782 Forest Avenue - ZBA Application #3010

From: **Lindsey Kelloway** <lindsey@bostonpie.com>
Date: Wed, Sep 13, 2017 at 3:04 PM
Subject: RE: 782 Forest Avenue - ZBA Application #3010
To: Christina Stacey <cstacey@portlandmaine.gov>

788 FOREST AVENUE PORTLAND, MAINE	
		PAVMENT STRIPING PLAN	
REV	DATE	DESCRIPTION	BY
McFarland Johnson 100 COMMER HILL DRIVE, SUITE 407 DANVER, MA PH: 978 408-4282		SCALE: AS SHOWN SOURCE: PFA CHECKED:	DESIGN: PFA PROJECT: DATE: 7/27/11
			CI

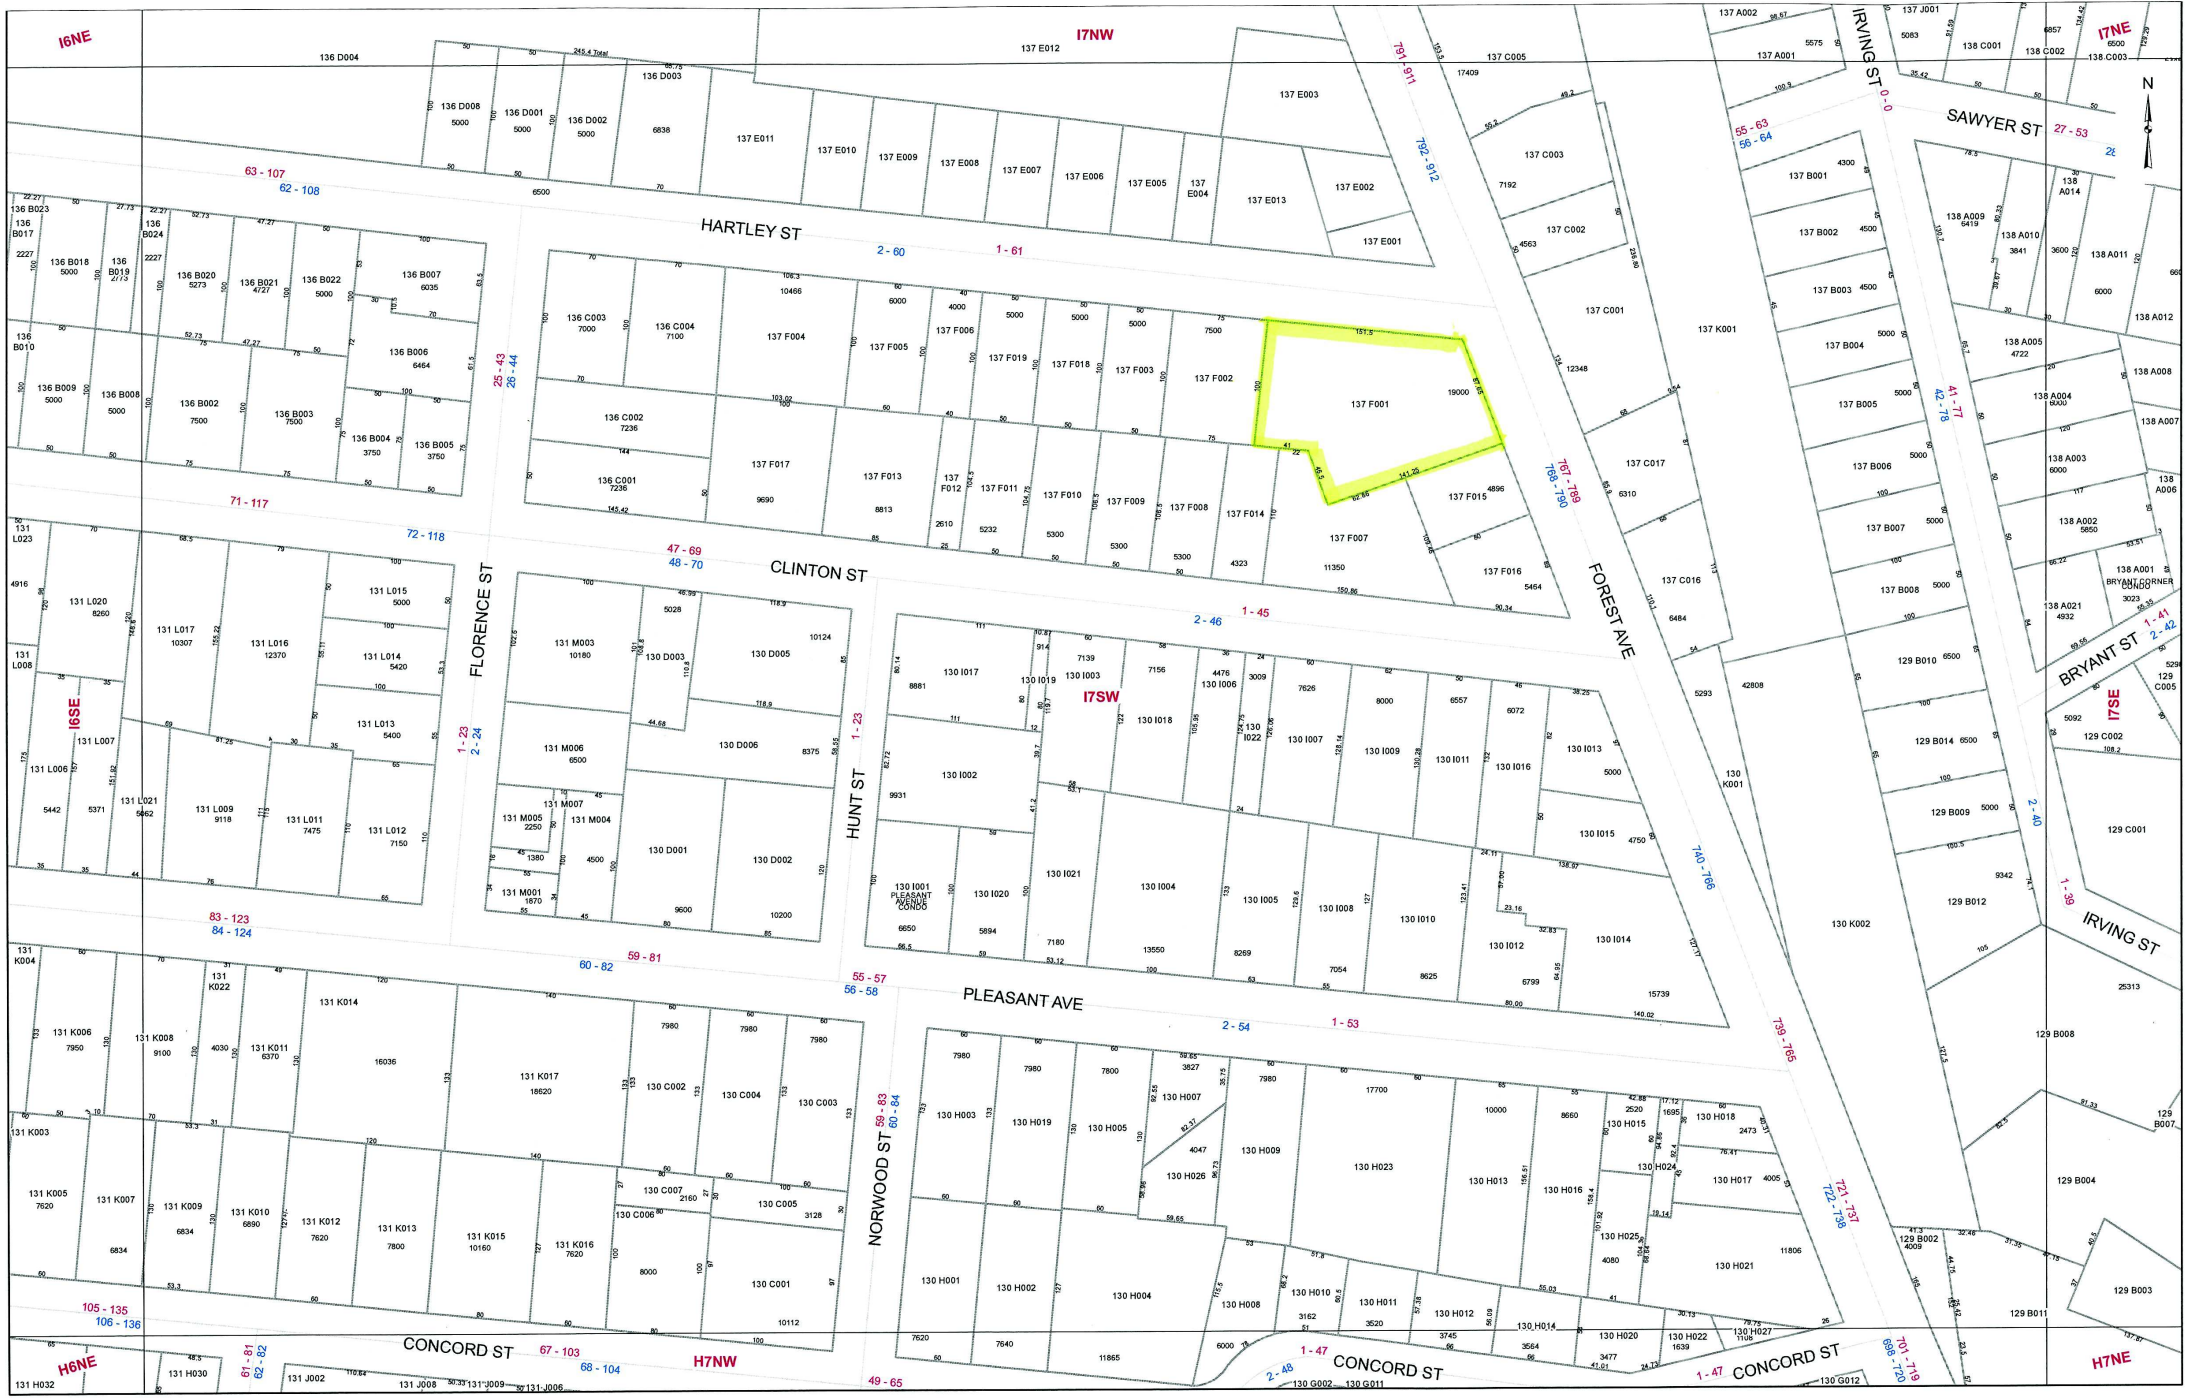
I would also recommend updating your plan to show the zone division line between the B-2c on the front part of the property and the R-5 on the rear part of the property. The impervious surface limitation applies only to the B-2c portion of the property.

With regards to the parking space that encroaches into the public way, I do not believe the ZBA has the authorization to grant approval for the parking space to remain on property not owned by you (i.e. on city-owned property). This is an encroachment issue between two property owners (you and the city) and cannot be appealed to the ZBA unless you have an argument against the facts as presented - for example, if you have a survey showing that the city doesn't actually own that property.
